September 14, 1988

RE: GRADING/PAVING PLAN FOR MOUNTAIN BELL @ 2327 ALAMO, SE
(M-16/D3A) REVISION DATE OF AUGUST 26, 1988

RE: DRAINAGE PLAN FOR MOUNTAIN BELL @ 2327 ALAMO, SE
(M-16/D3A) RECEIVED AUGUST 9, 1988

GRADING & DRAINAGE PLAN

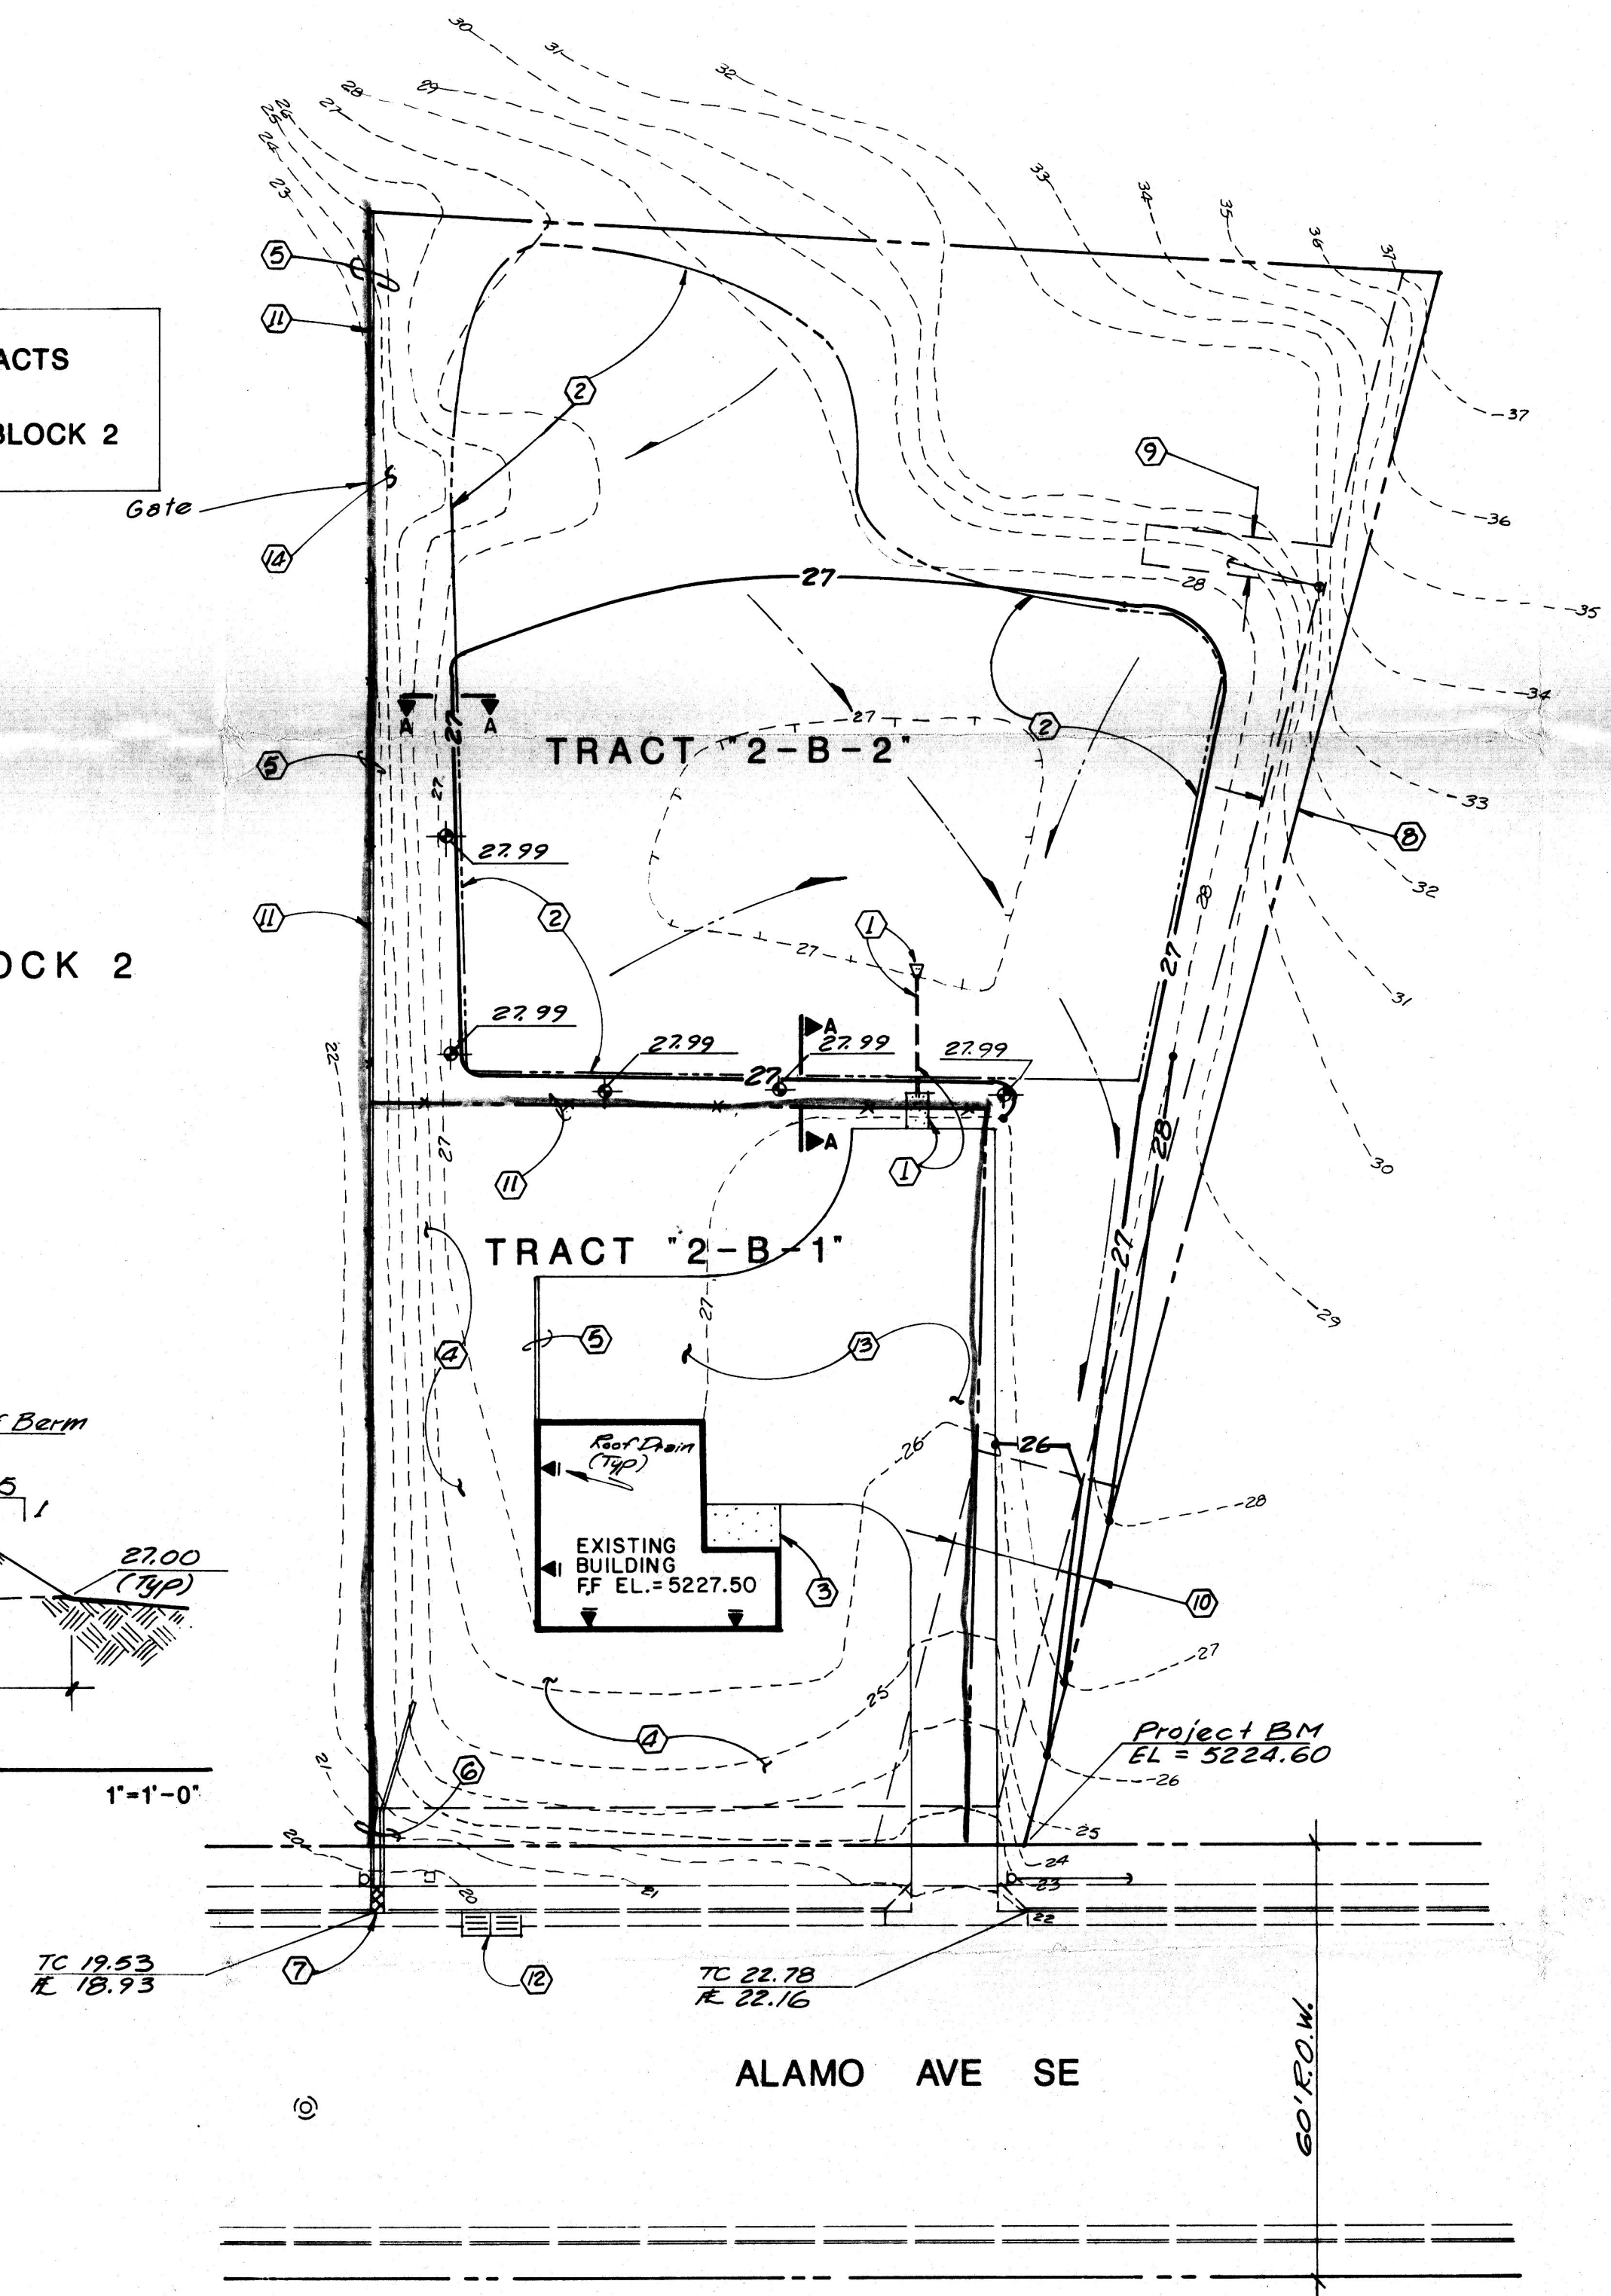
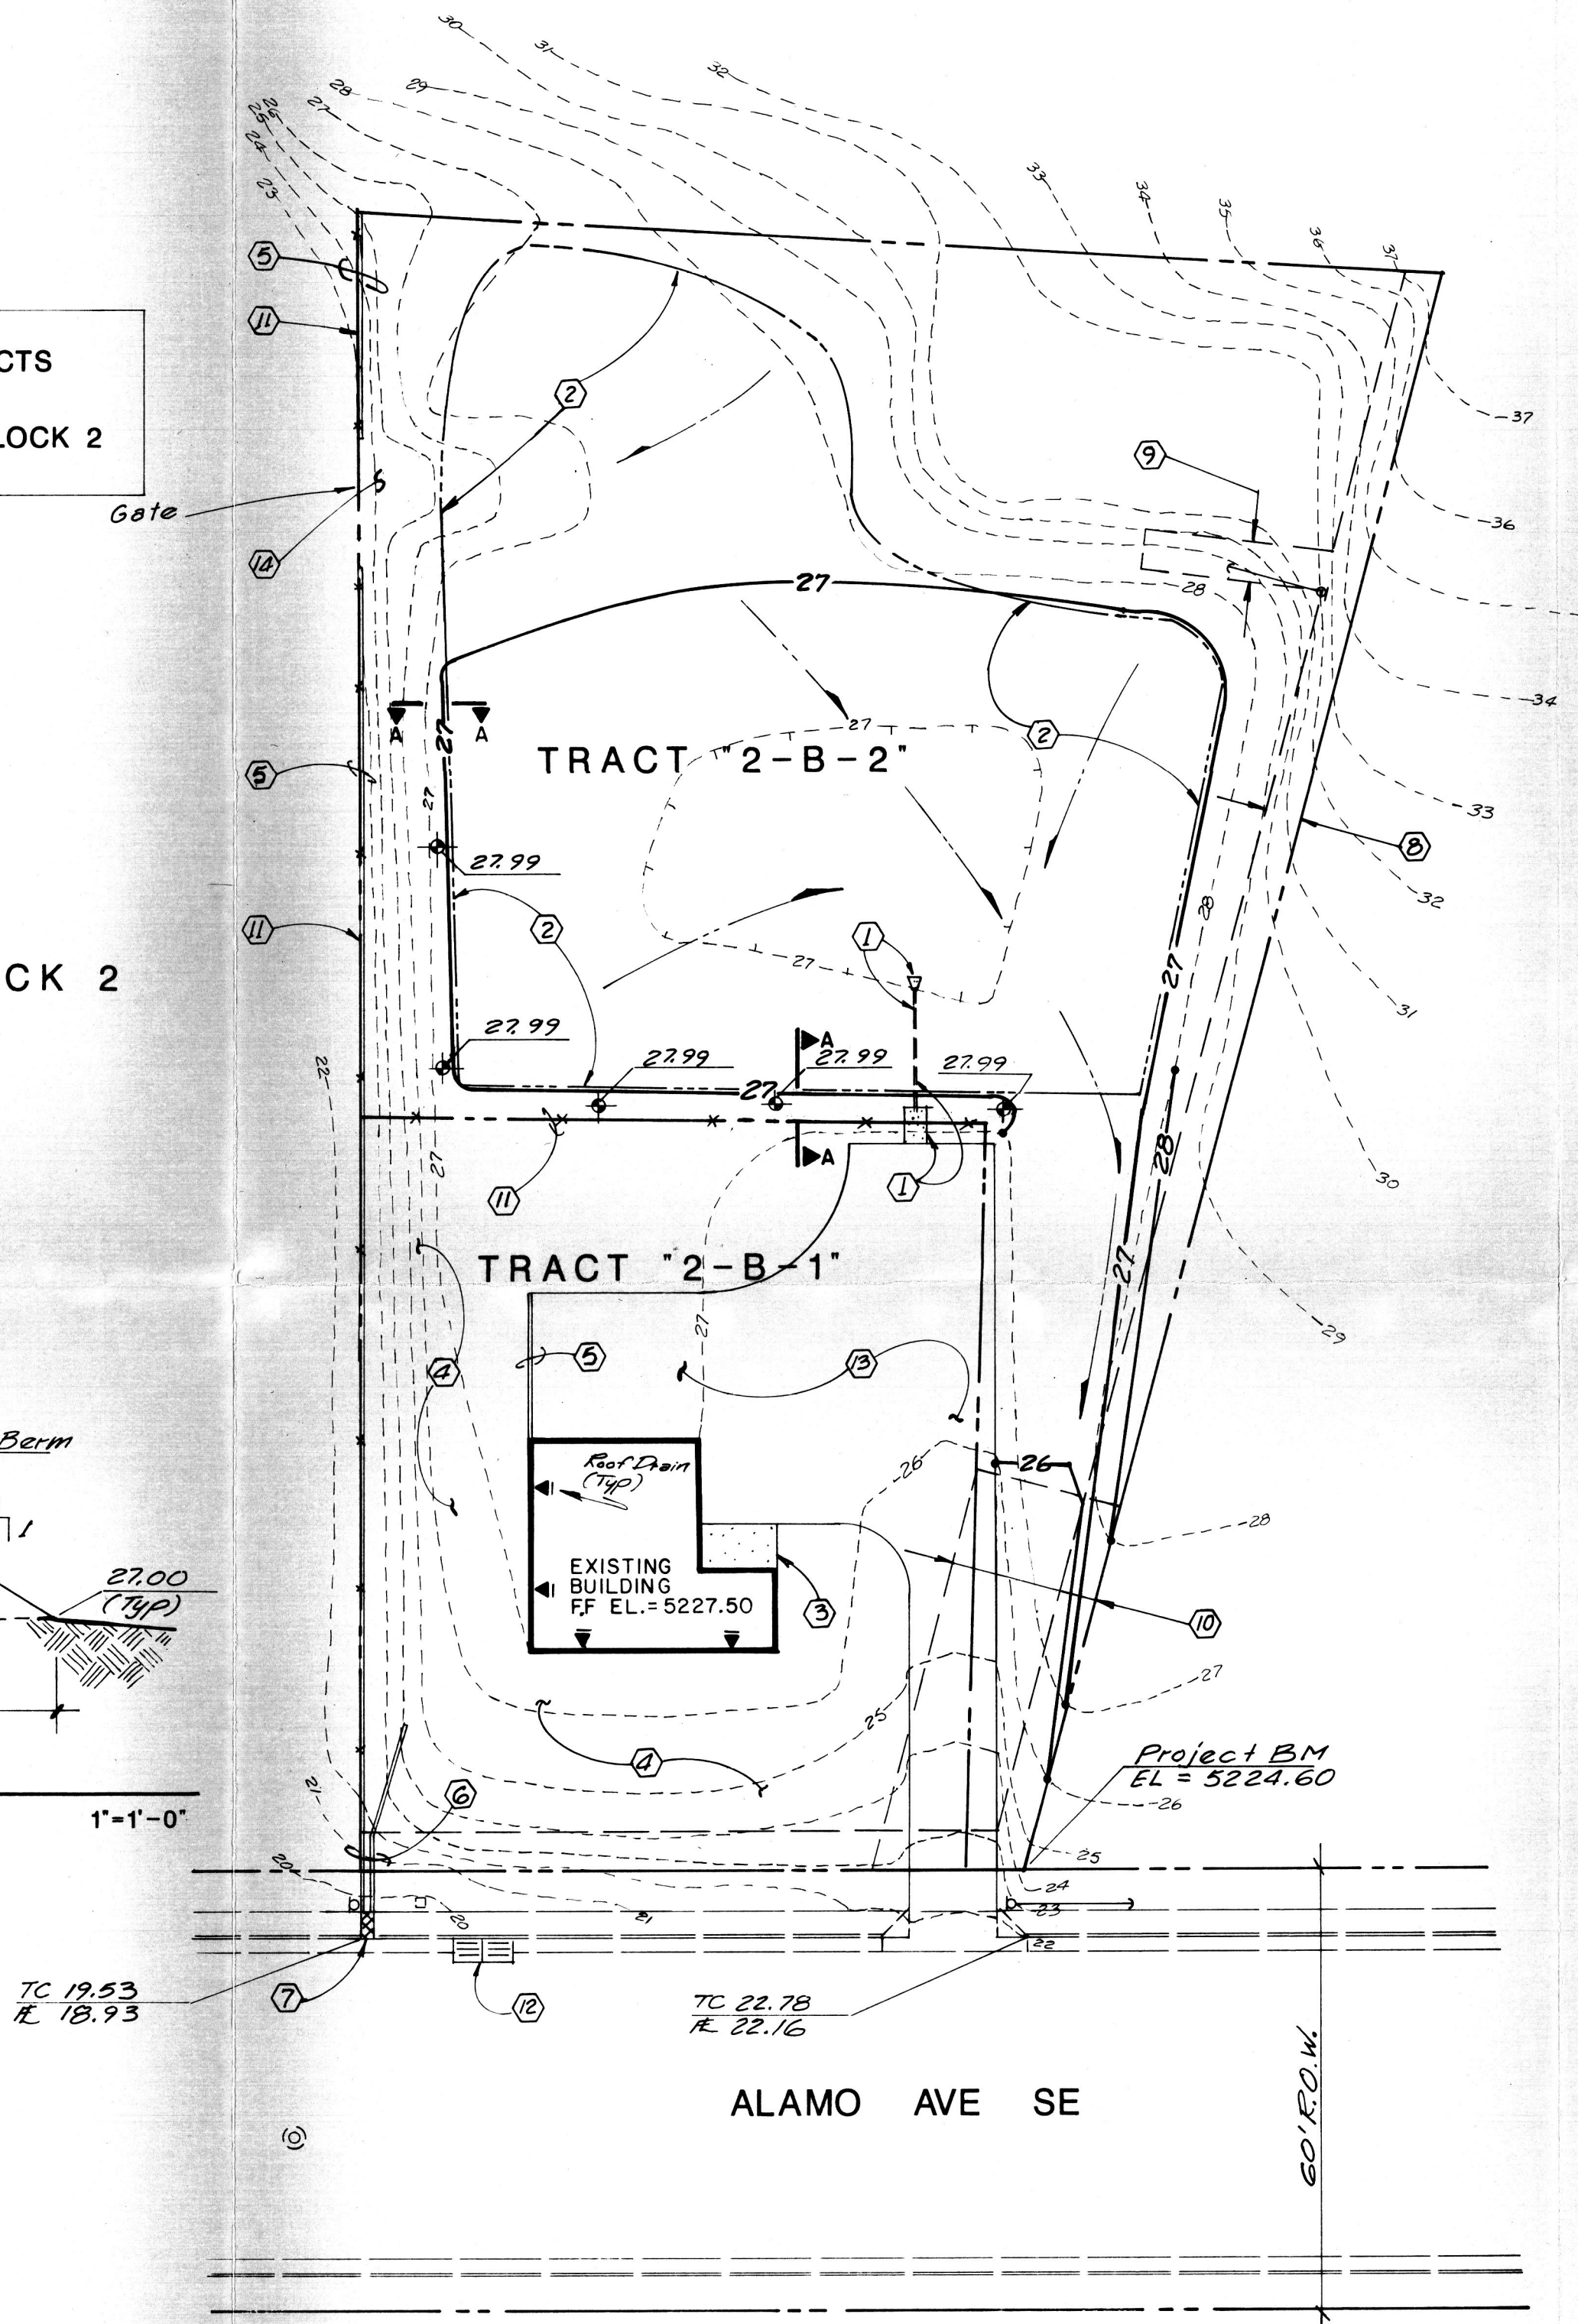
1. Quantification of offsite rate of flow caused by the contributing watershed. You must accept the offsite flows from the existing undeveloped site to the east.
2. Once the offsite flows enter the site, how do you propose to handle them.
3. We will need an easement or replat for cross lot line drainage. Even if the properties are owned by the same owner, we will need something that will run with the land.
4. What type of compaction specifications do you propose for the earth berm.

Based on the information provided on your resubmittal of September 1, 1988, the referenced drainage plan is approved for Grading/Paving Permit.

Also, a copy of the compaction tests on the berm must be on hand when the inspection is conducted.
